Objection to Residential Development with affordable housing 11-19 Middle Harbour road Road Lindfield (SSD-82900461)

WEST ELEVATION
1:200

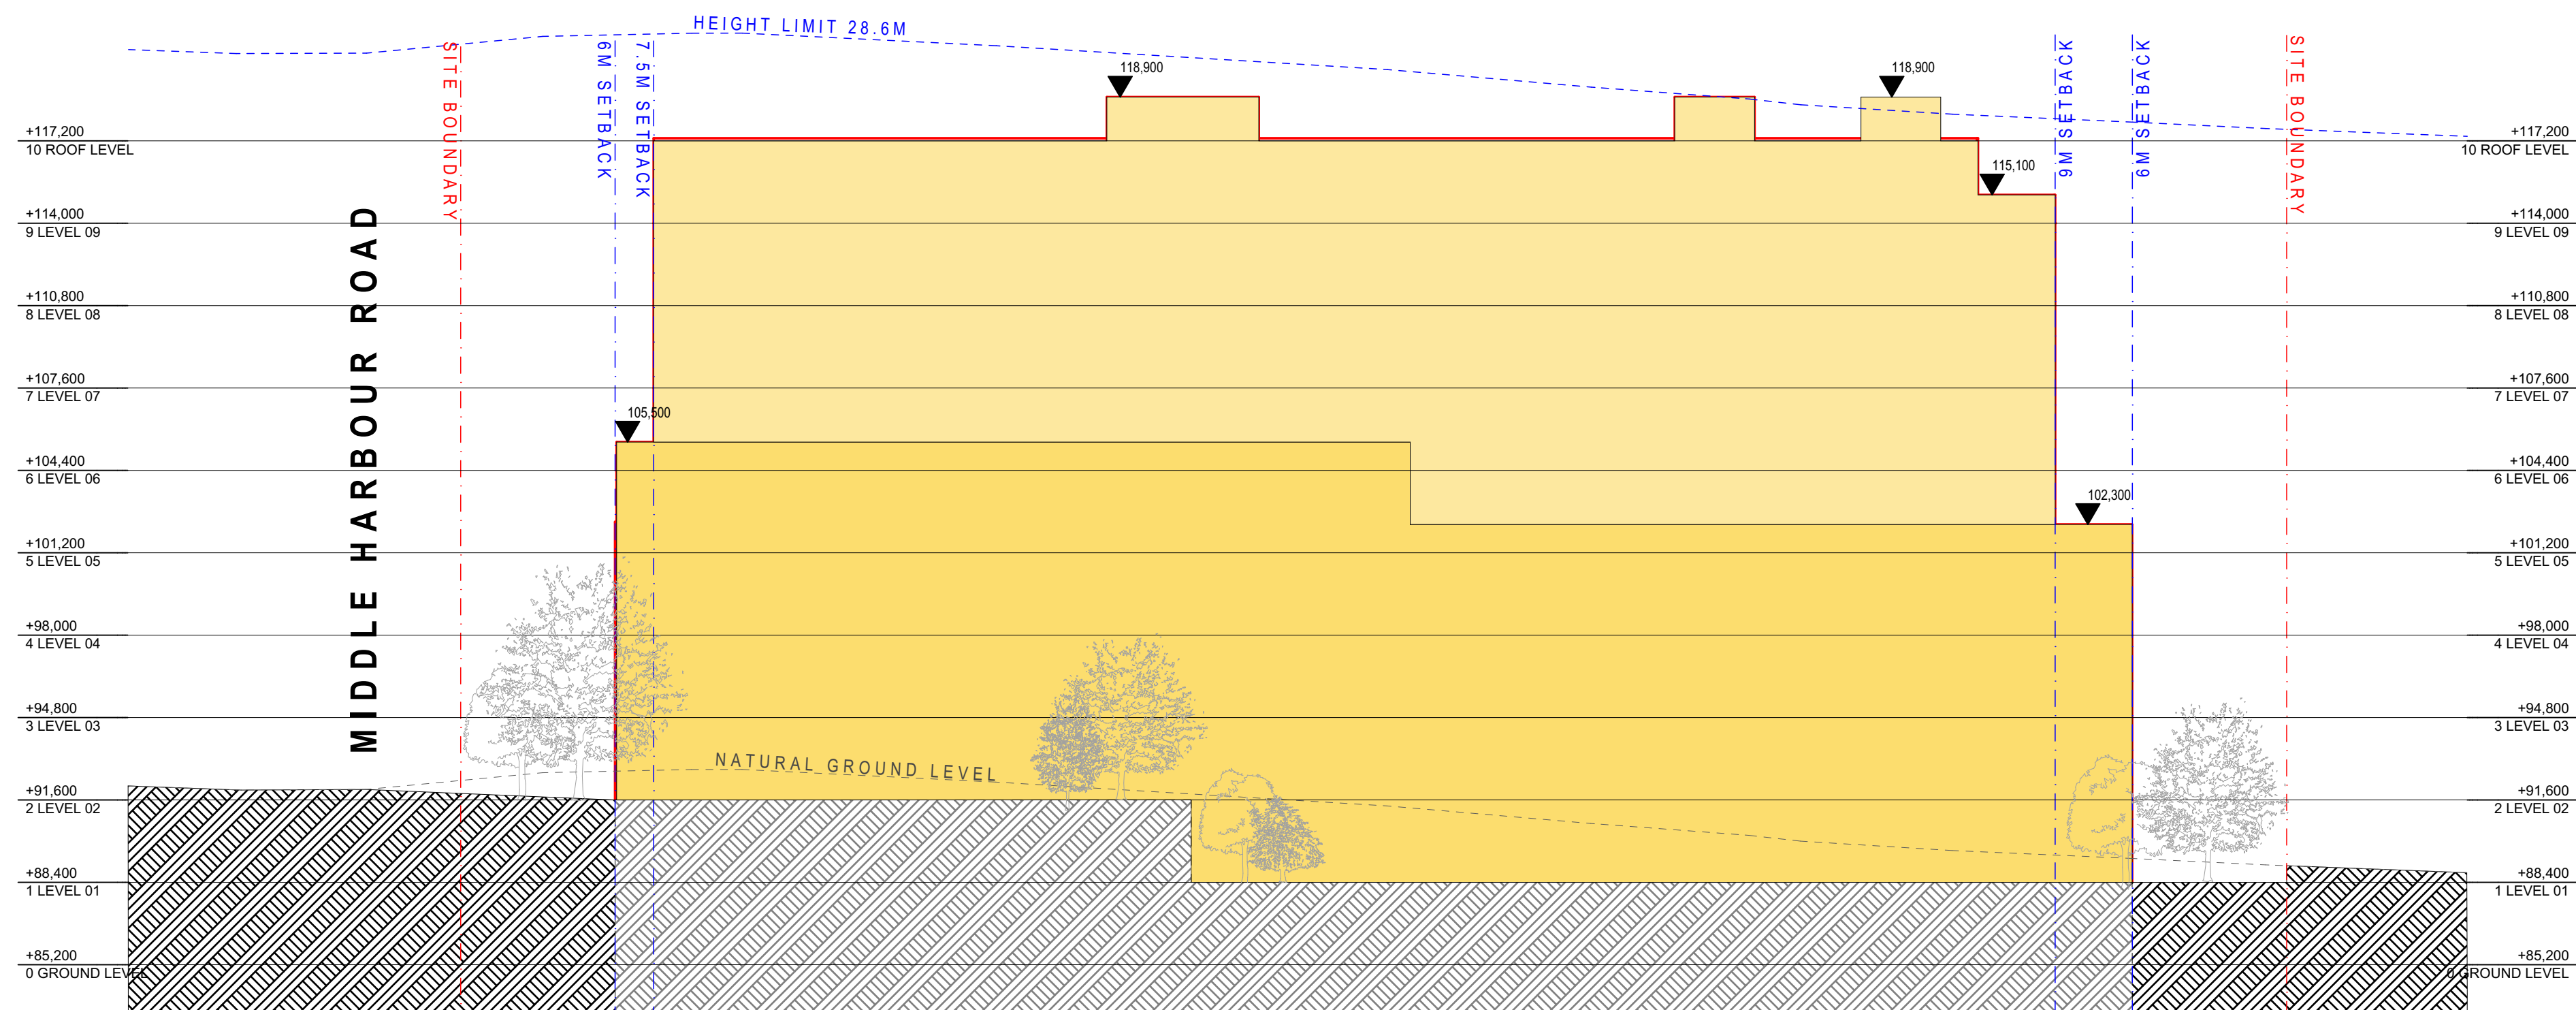
While the Project falls within the "Preferred Alternative" area, building heights in the area are limited to 18 meters to meet planning requirements for transitioning from a high-density to a low-density zone. However, the current design for the Project's buildings exceeds 30 meters, significantly contradicting the KRG's "Preferred Alternative" in both height and bulk.

Drawing Name
Shadow Diagrams - June 21

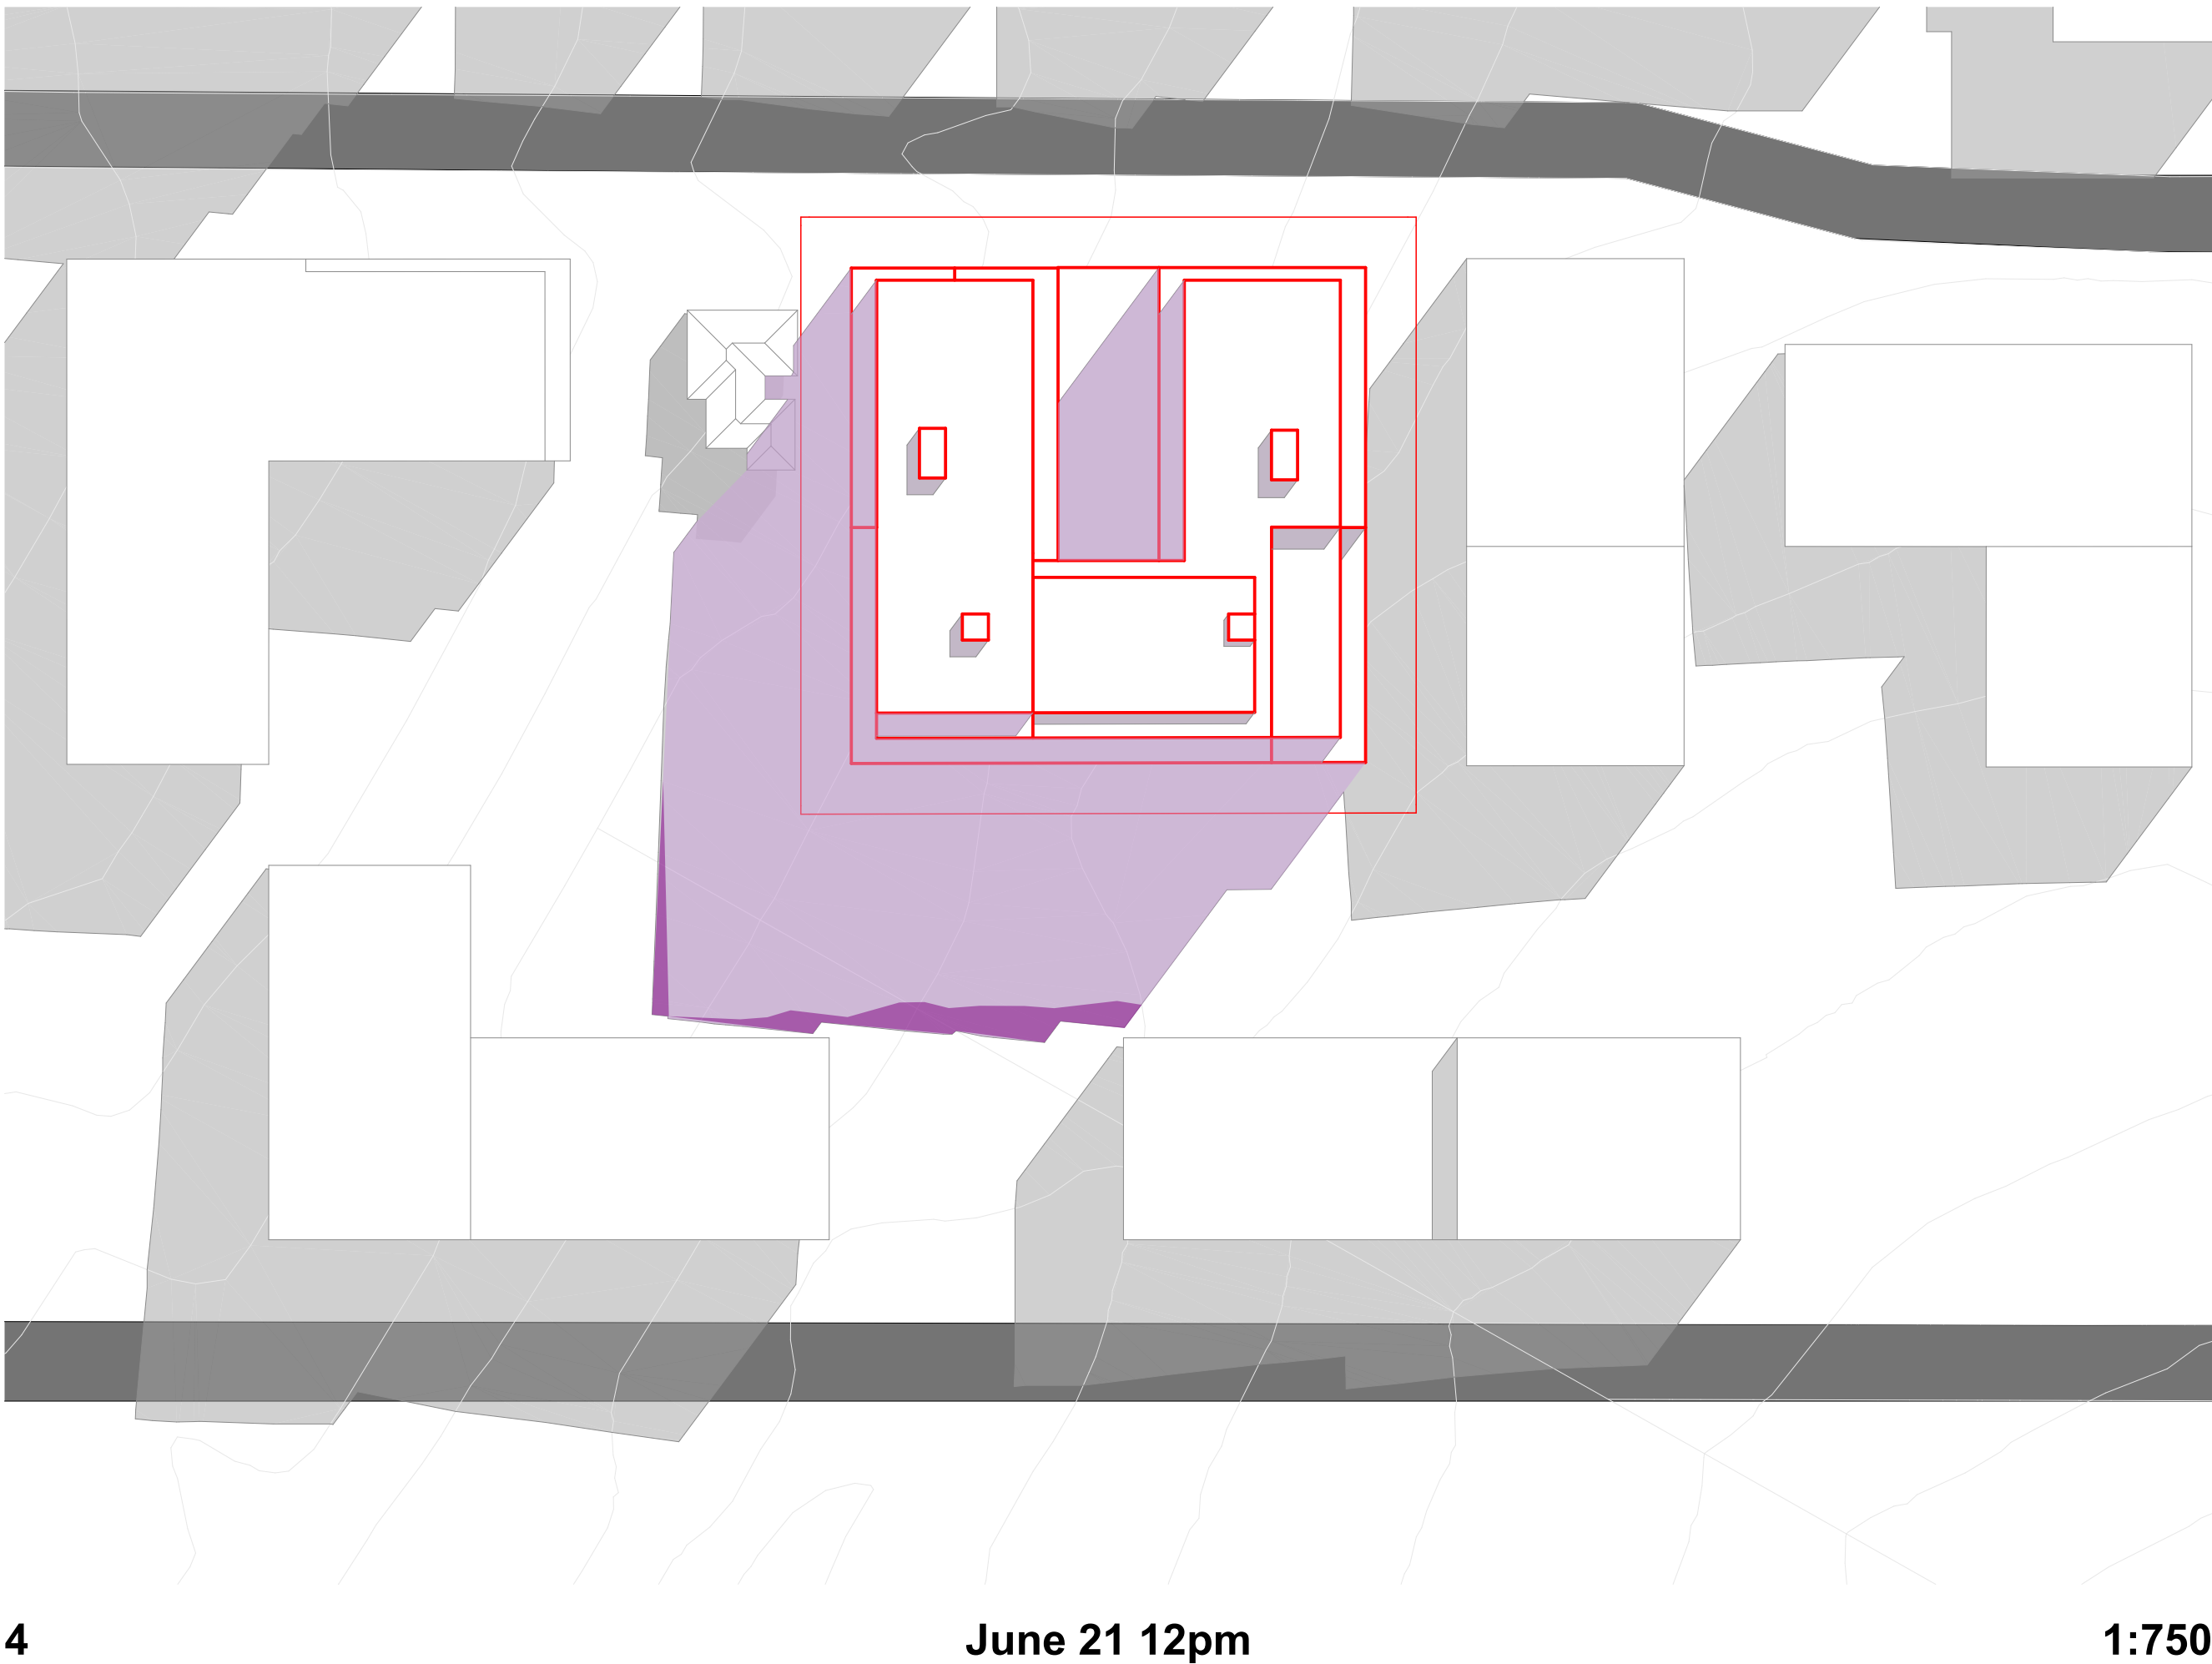
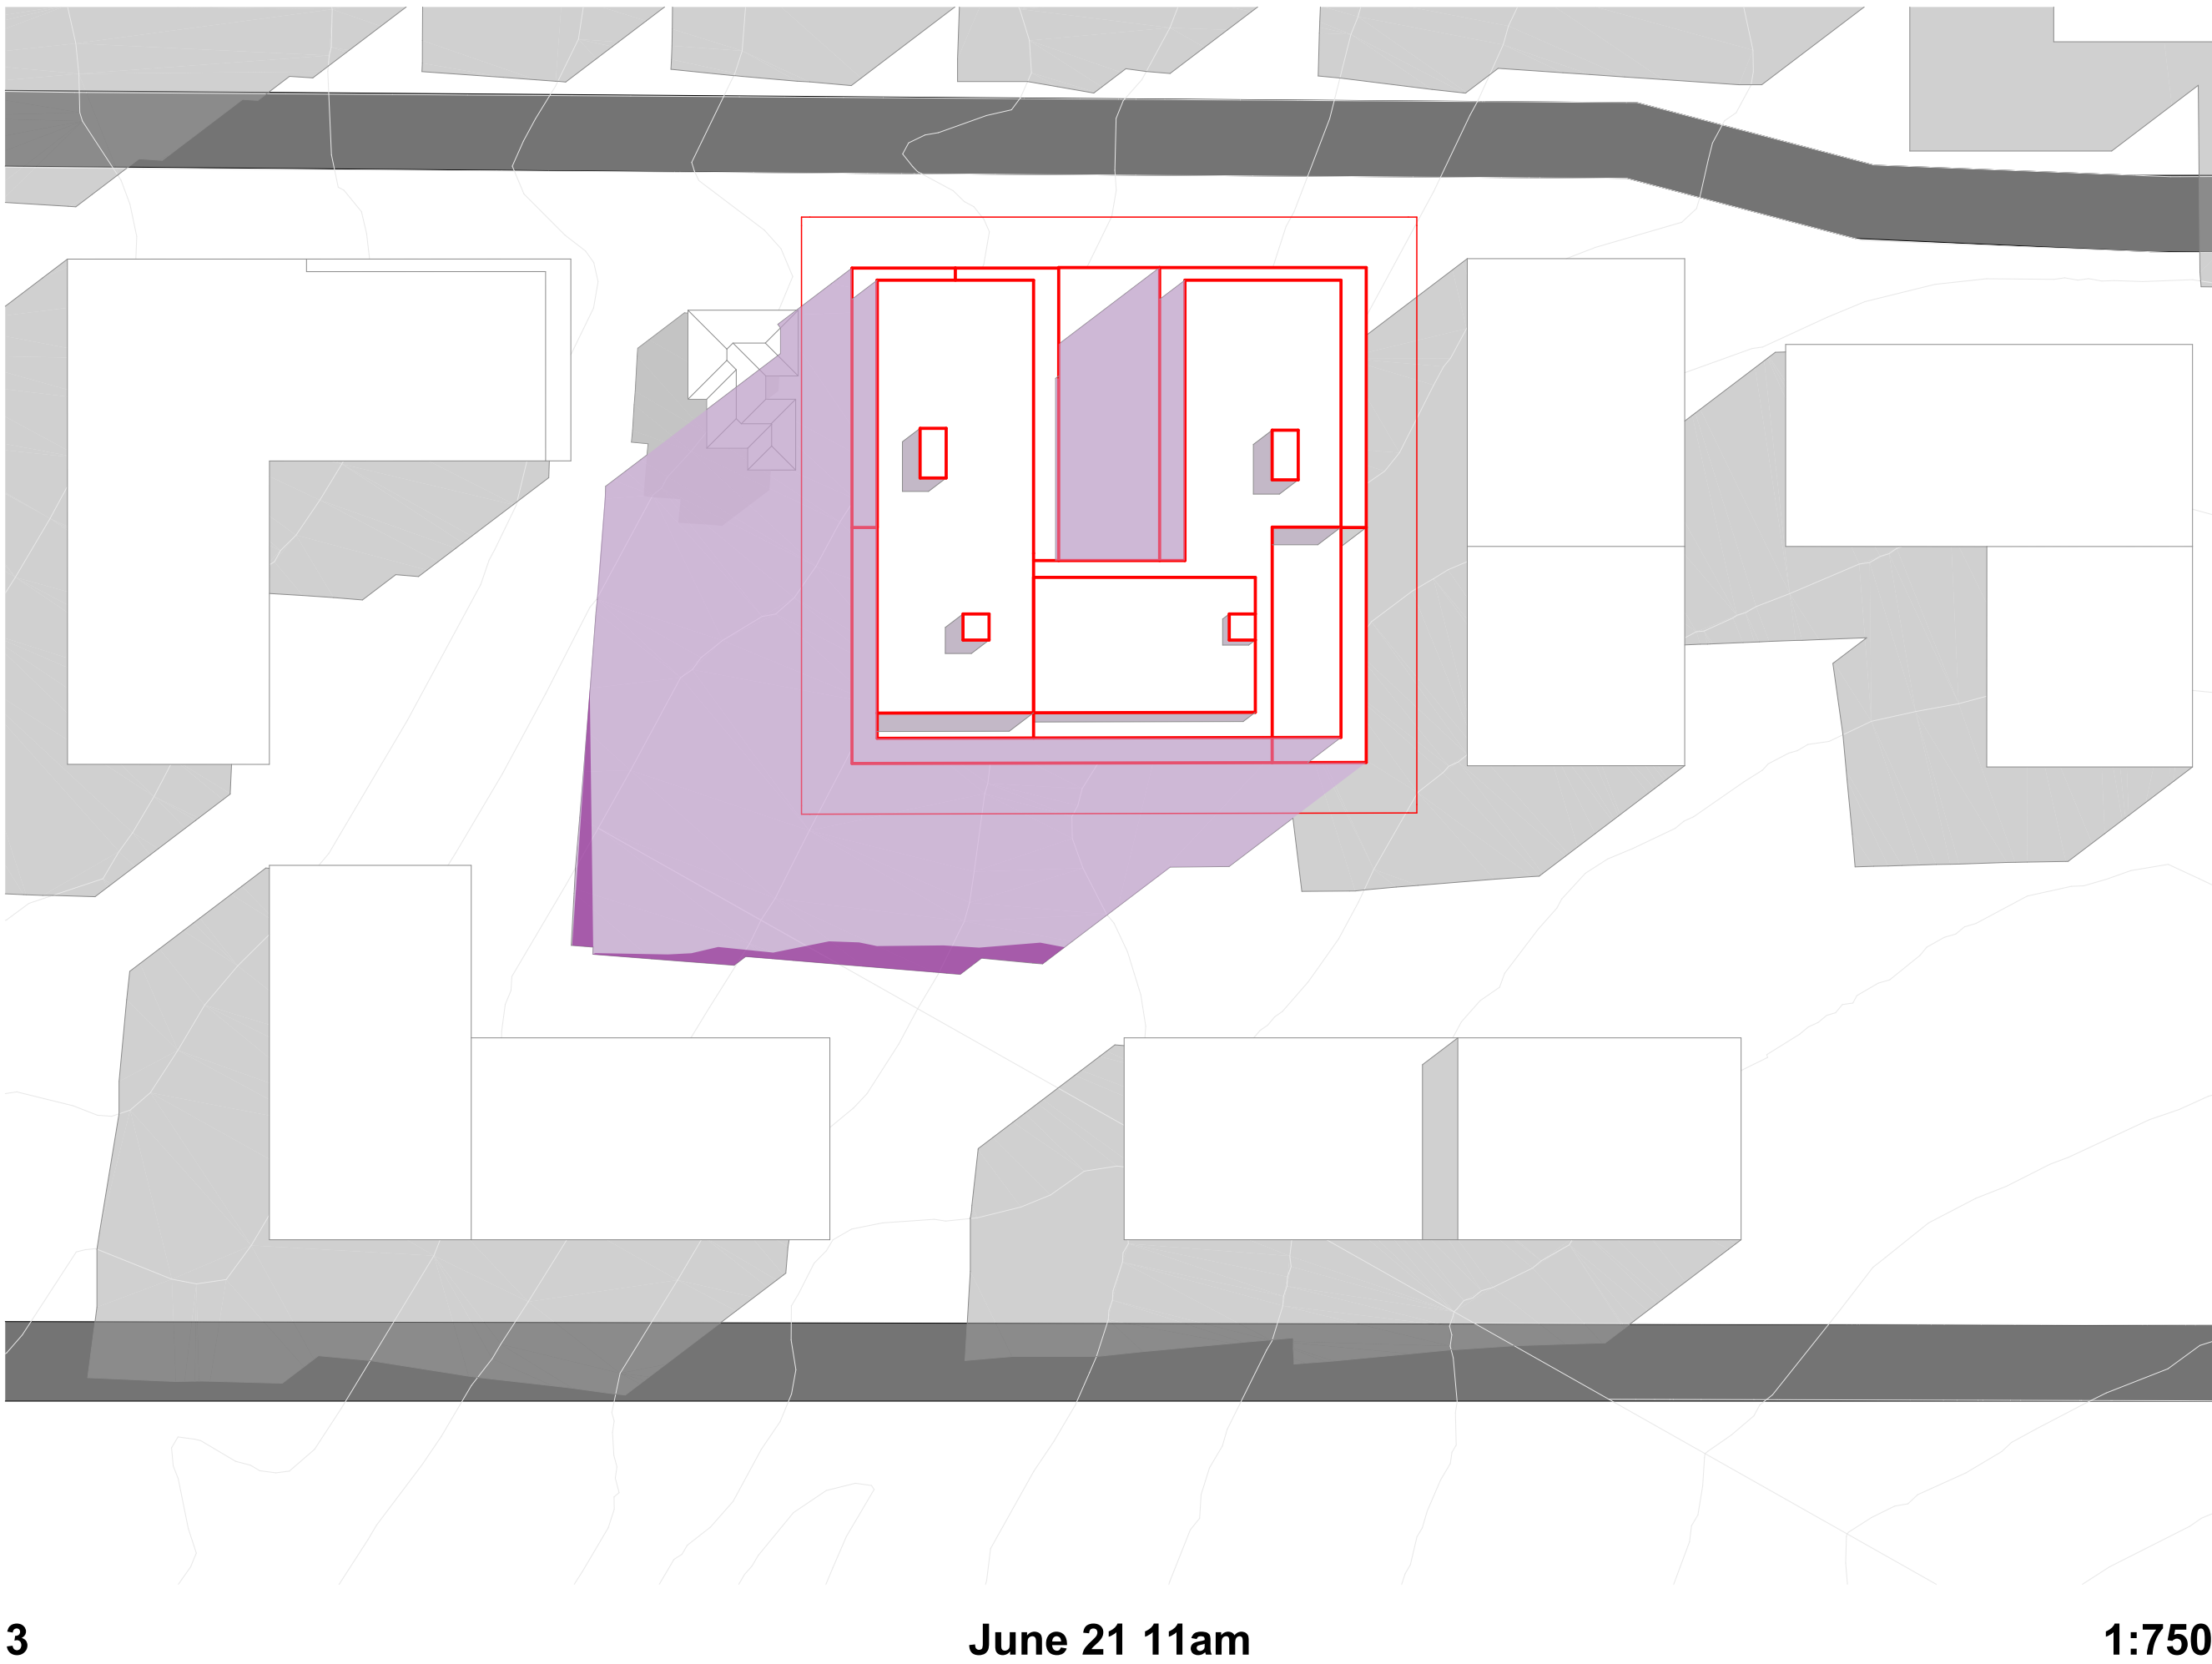
The land which "the Project" is located is higher in the north and lower in the south. Therefore, the setback on the southern boundary of "the Project" should be larger to minimize the shadowing effect on the buildings along Chelmsford Road, which are located at a lower elevation than the Project.

However, the Project does not actually follow the relevant setback rules of KCDP2024. Therefore, “the Project” will cause serious shadowing effect on the direct sunlight of the buildings along Chelmsford Road.
